A1 in Northumberland: Morpeth to Ellingham

Scheme Number: TR010059

7.6A Statement of Common Ground with Northumberland County Council

**Statement of Common Ground with
Northumberland County Council**

highways  
england

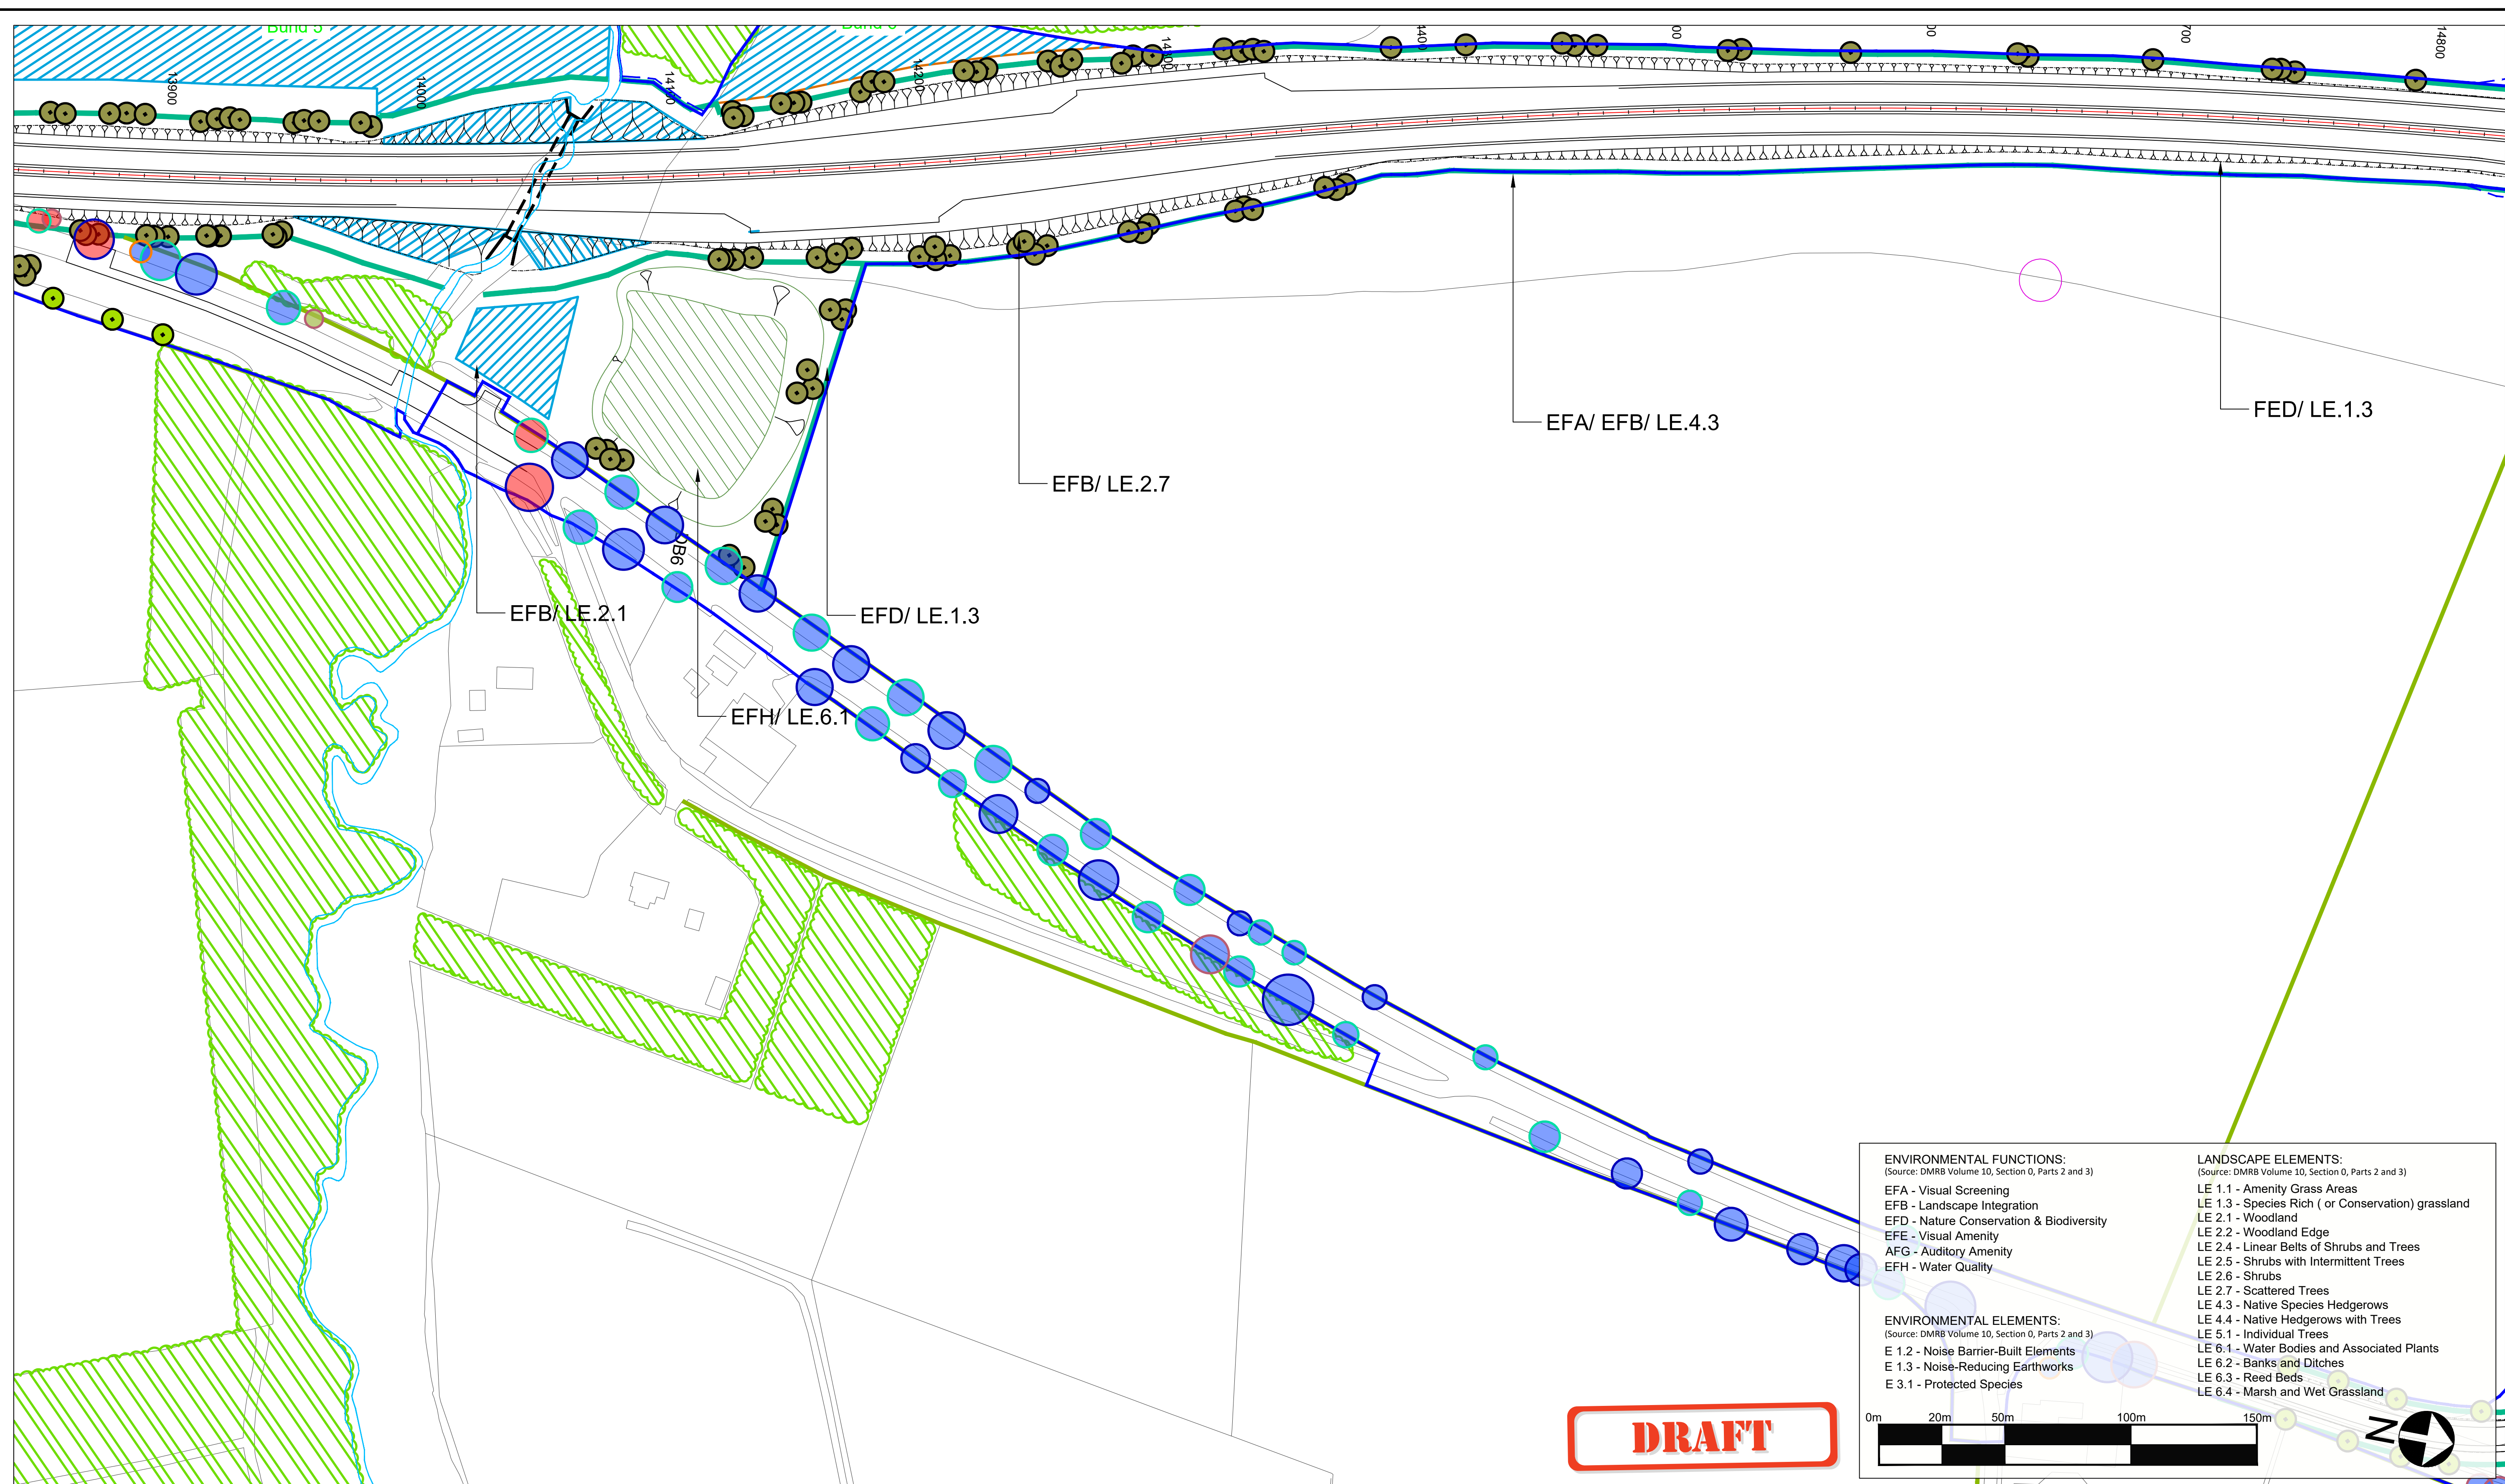
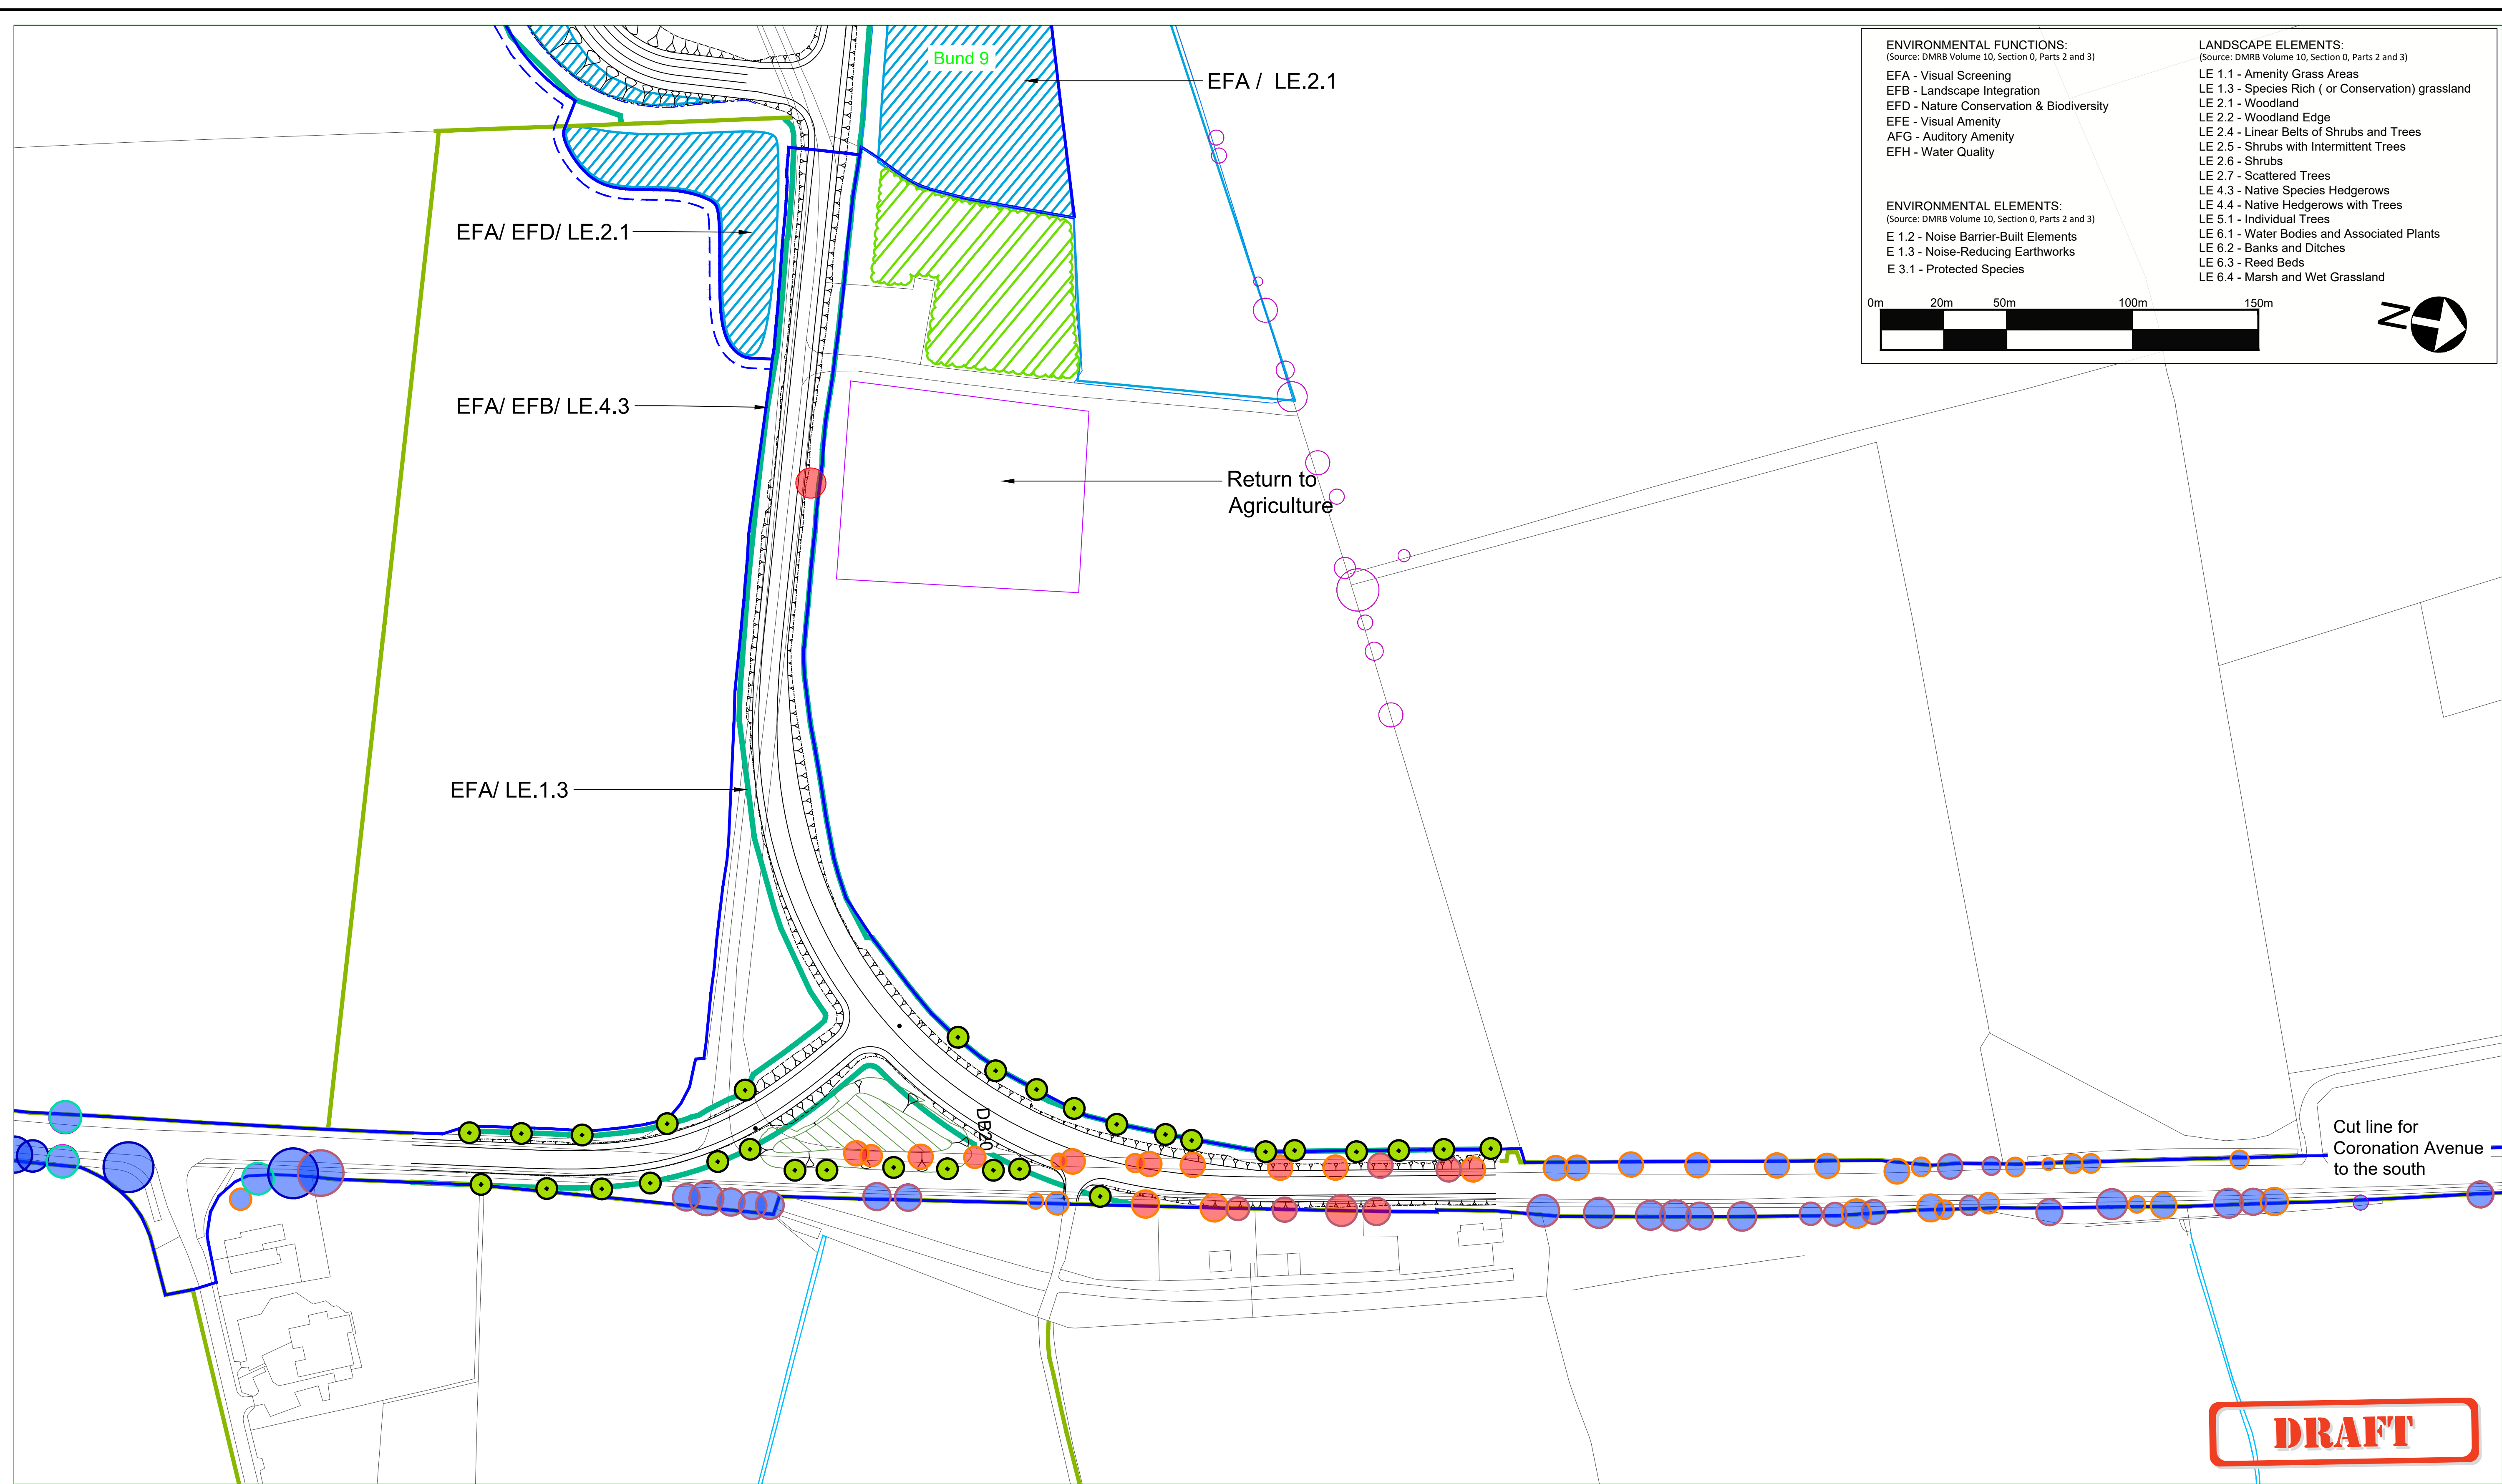
Date	Form of Correspondence	Key Topics Discussed and Key Outcomes
6/1/21	Email exchange with Mary Fisher, and Andy Williams (on behalf of the Applicant)	Key Topic Email exchange regarding the design of the Coronation Avenue (number, spacings and frequency). Reference to further discussion with NCC tree officer to also get feedback. Key Outcome Email received from NCC confirming that they are in agreement with the proposed replacement strategy for the Coronation Avenue, as per Appendix LV.2 to Written Question LV.1.8 at Deadline 1 [REP1-032].
07/01/21	Call between NCC and drainage specialist.	Key Topic and Outcome Follow up call to discuss surface water drainage strategy for the Scheme.
14/01/21	Meeting with NCC and the Applicant	Detailed discussion around issues identified with the Rights of Way and Access Plans and DCO Schedules. Key Topic NCC stated that it was unclear from the DCO plans which roads are to be adopted and which are not. NCC also requested clarification as to the extents of stopping up of the existing A1 at the southern end of the detrunking section, at Priest's Bridge. NCC believe stopping up of highway should continue further south than is shown on the Rights of Way and Access Plans. NCC stated that the extent of soft estate to be adopted is unclear, with respect to earthworks, verge, landscaping and detention basins. Key Outcome A scheme overview plan showing the extent of roads to be adopted was produced and issued to NCC on 08/02/21. Extents of stopping up of the existing A1 at the southern end of the detrunking section, at Priest's Bridge, amended as per NCC's suggestion. Updated Rights of Way and Access Plans issued at Deadline 02. [REP2-003]. The Applicant is unable to confirm exact limits of soft estate to be adopted at present. Such details are subject to detailed design, with the exception of the detention basins for adoption which can and will be confirmed.
